DECISION DELEGATED TO HEAD OF PLANNING

Application No: H16-0803-21 **Applicant:** Mr I Buckley

Proposal: Extensions and alterations and replacement septic tank

Location: 145 Bourne Road Spalding

Proposed Ground Floor Plan

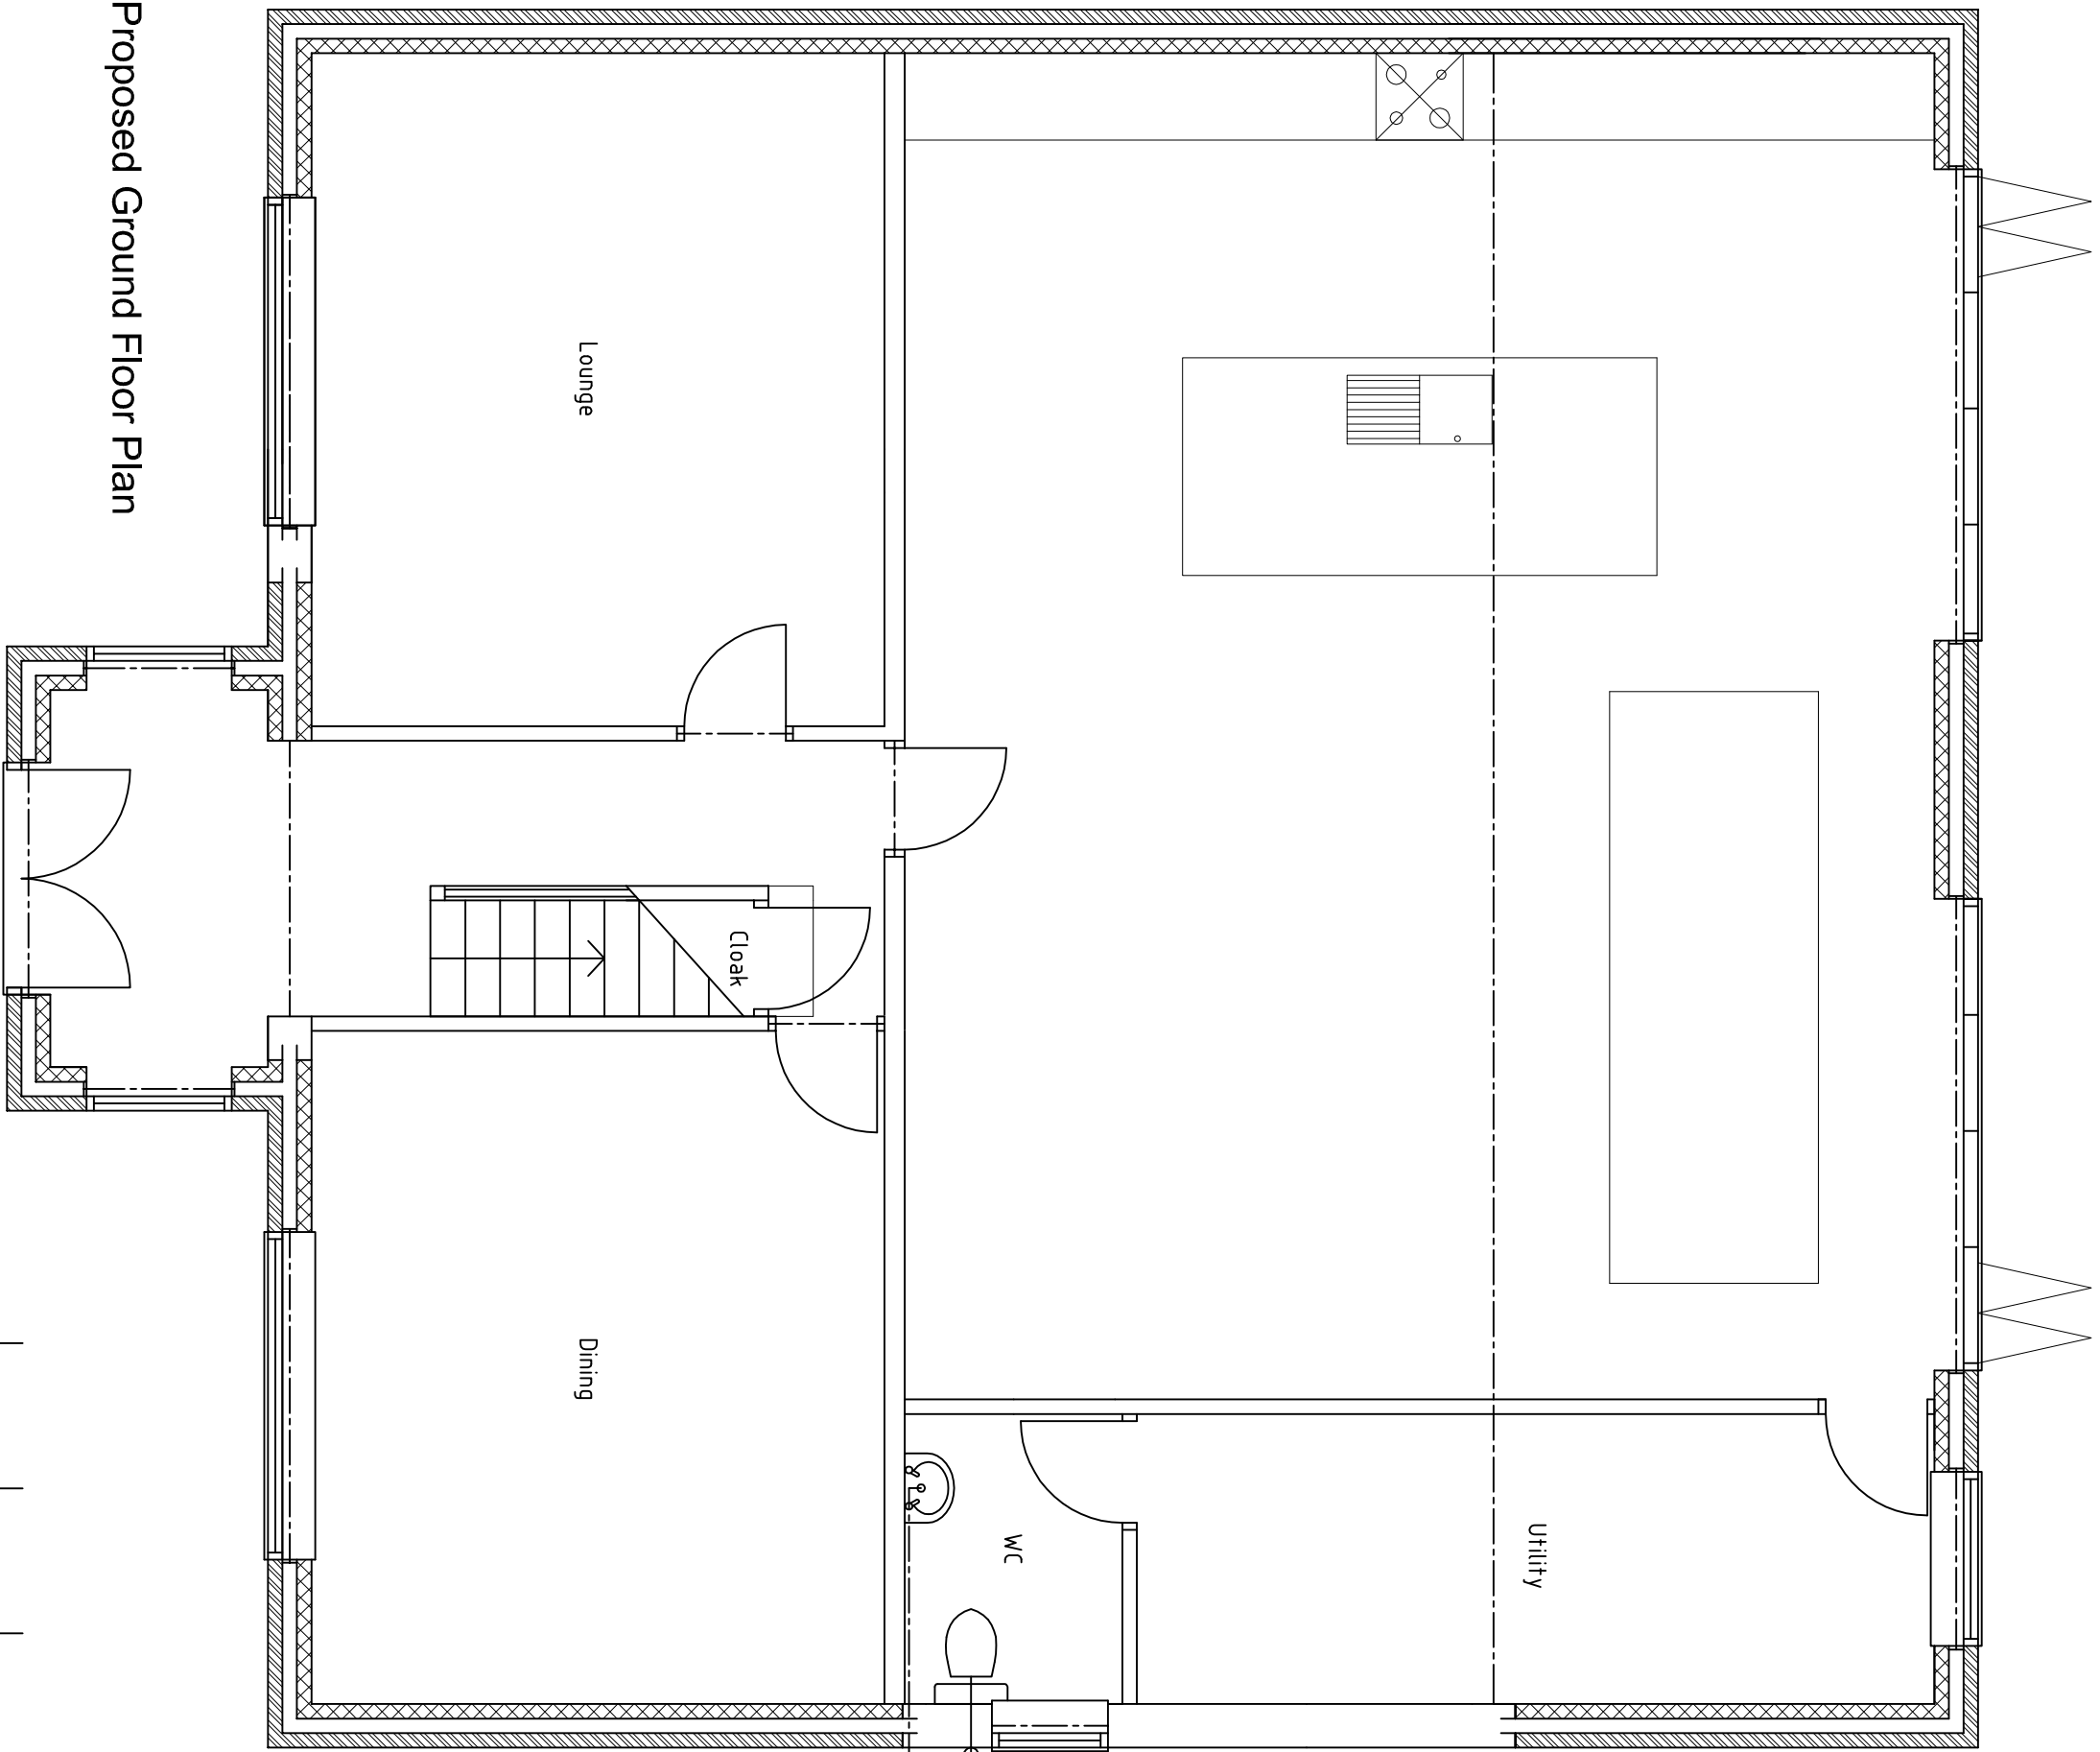
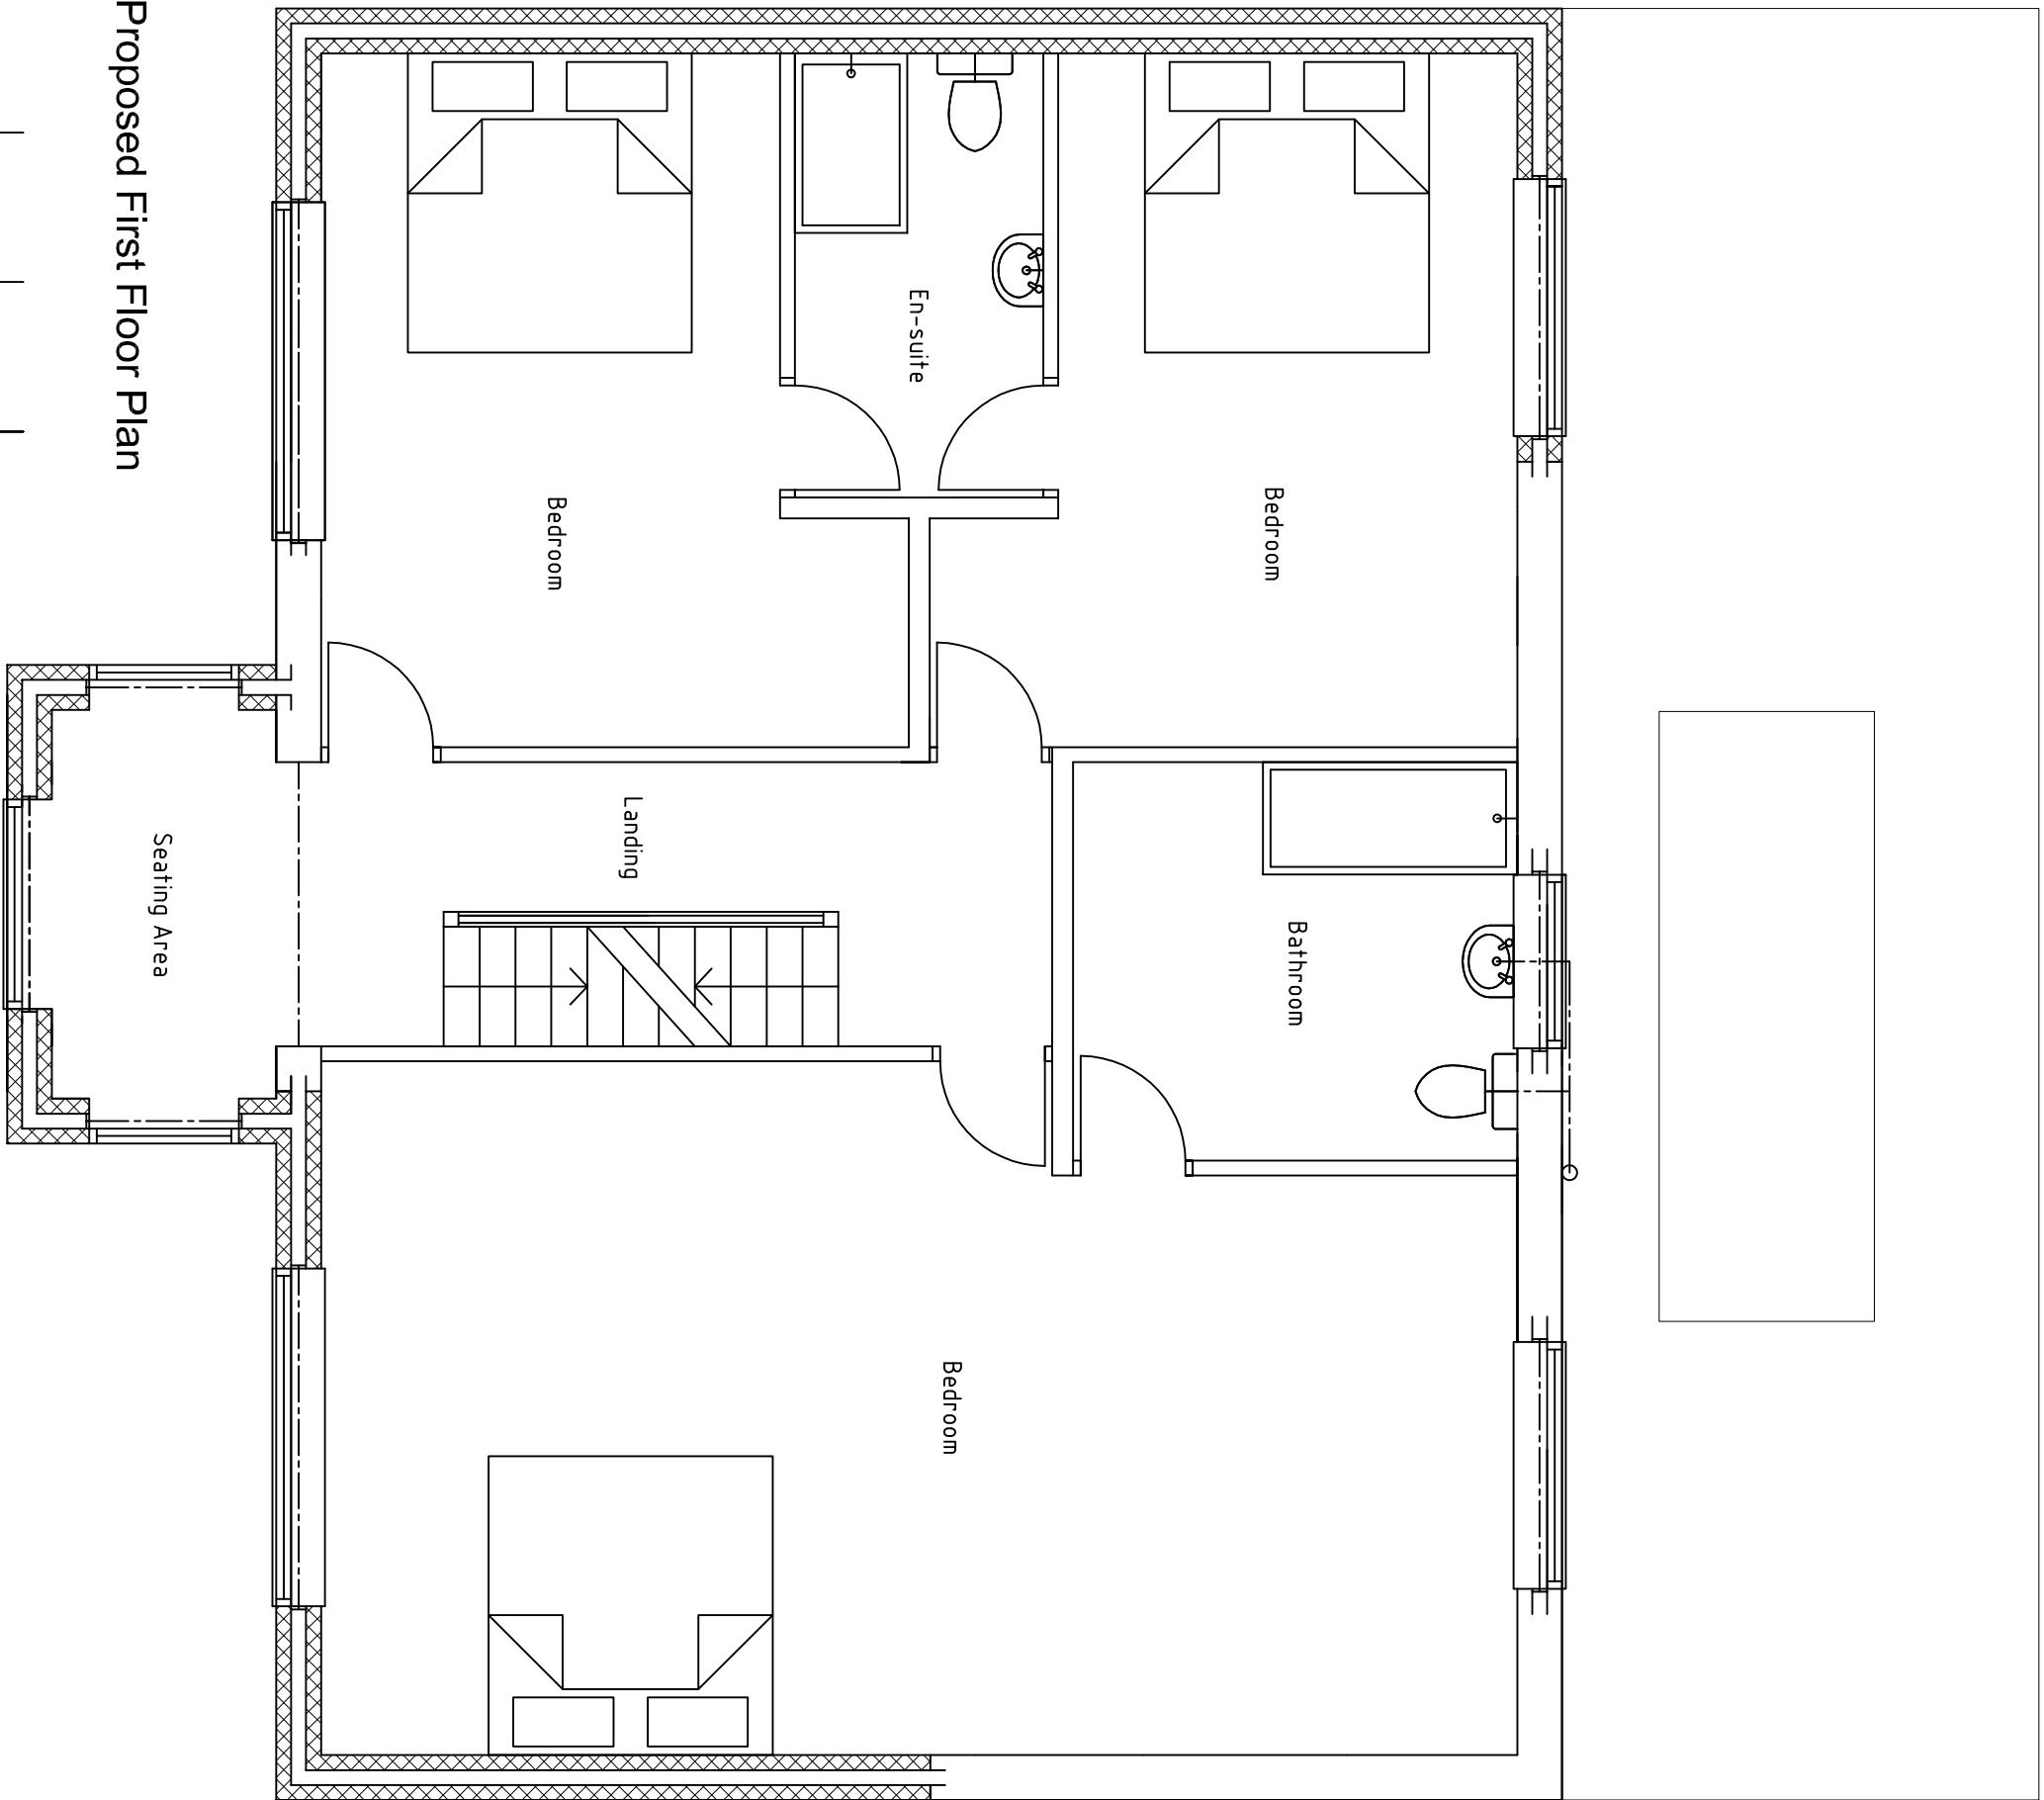
The proposal involves squaring off the front of the dwelling between the side dining room and front lounge elevations, and a minor two storey entrance hall and seating area being constructed to the front of this. The rear extension will project approx. 3.1m from the existing elevation. This would appear to only extend marginally further than the rear extension to no.143. and almost as far as the furthest rear elevation of no. 147. The property will also be extended above the garage, with the

In terms of internal alterations to the dwelling, this comprises of a new lounge and dining room to the front section of the ground floor and a large open plan kitchen, dining room and utility to the rear section. To the first floor, this will include 3 enlarged bedrooms, two with a jack and jill bathroom and the master bedroom with an ensuite bathroom. There will be an additional second floor created, with a bedroom including a walk in wardrobe and ensuite. This is in keeping with the residential use of the property.
